KITTITAS COUNTY

MEMORANDUM

TO: All Staff
FROM: Public Works Plan Review Team
DATE: August 22, 2024
SUBJECT: SP-24-00011 Lewis

LEWIS SHORT PLAT PART OF SECTION 29, T. 17 N., R. 20 E., W.M. KITTITAS COUNTY, WASHINGTON

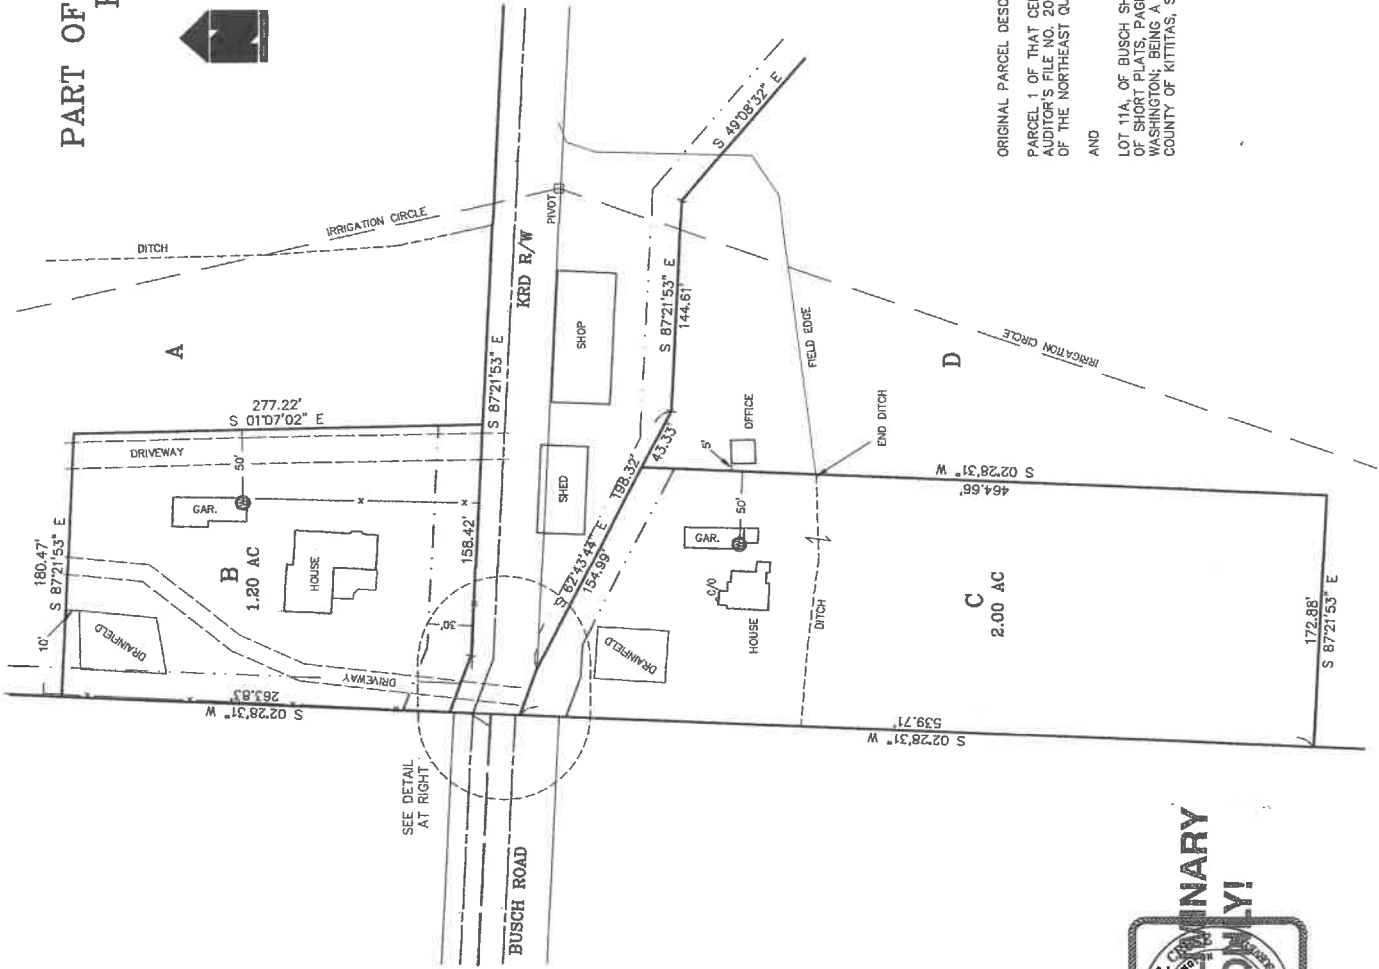
<p>Please show the width and recording information for the existing easement through the middle of Lot A.</p> <p>OF NOTE Lot closures were not reviewed as part of this submittal. Lot Closures will be reviewed at final. Title report was reviewed as part of this submittal. Ownership and legal description is fine. (JT)</p>
TRANSPORTATION CONCURRENCY	No transportation concurrency requirement for this project. (KAH)
FLOOD	The proposed short plat is not located in a FEMA identified special flood hazard area (100-year floodplain). A floodplain development permit is not required for the project. (SC)
WATER MITIGATION/ METERING	<p>The following comments outline the requirements for legal availability of water and metering for the proposed short plat:</p> <p>The applicant must provide legal water availability for all new uses on the proposed lots of this project, which can be provided through mitigation certificates. Prior to final plat approval and recording, the following conditions shall be met:</p> <p>In accordance with KCC Chapter 13.35.027, the applicant shall provide one of the following documents before final plat approval:</p> <ol style="list-style-type: none"> 1. A letter from a water purveyor stating that the purveyor has adequate water rights and will provide the necessary water for the new use; 2. An adequate water right for the proposed new use; or 3. A certificate of water budget neutrality from the Department of Ecology or other adequate interest in water rights from a water bank. <p>All applicants for land divisions shall also submit information on "proximate parcels" held in "common ownership" as those terms are defined in WAC 173-539A-030 and otherwise demonstrate how the proposed new use will not violate RCW 90.44.050 as currently existing or hereafter amended.</p> <p>Failure to obtain mitigation before commencement of an activity requiring mitigation shall be a code violation subject to enforcement under Title 18 KCC.</p> <p>Final Plat Notes</p> <p>The following notes shall be placed on the face of the plat:</p> <p>C-1 "Metering is required for all new uses of domestic water for residential well connections and usage must be recorded in a manner consistent with Kittitas County Code Chapter 13.35.027 and Ecology regulations."</p>
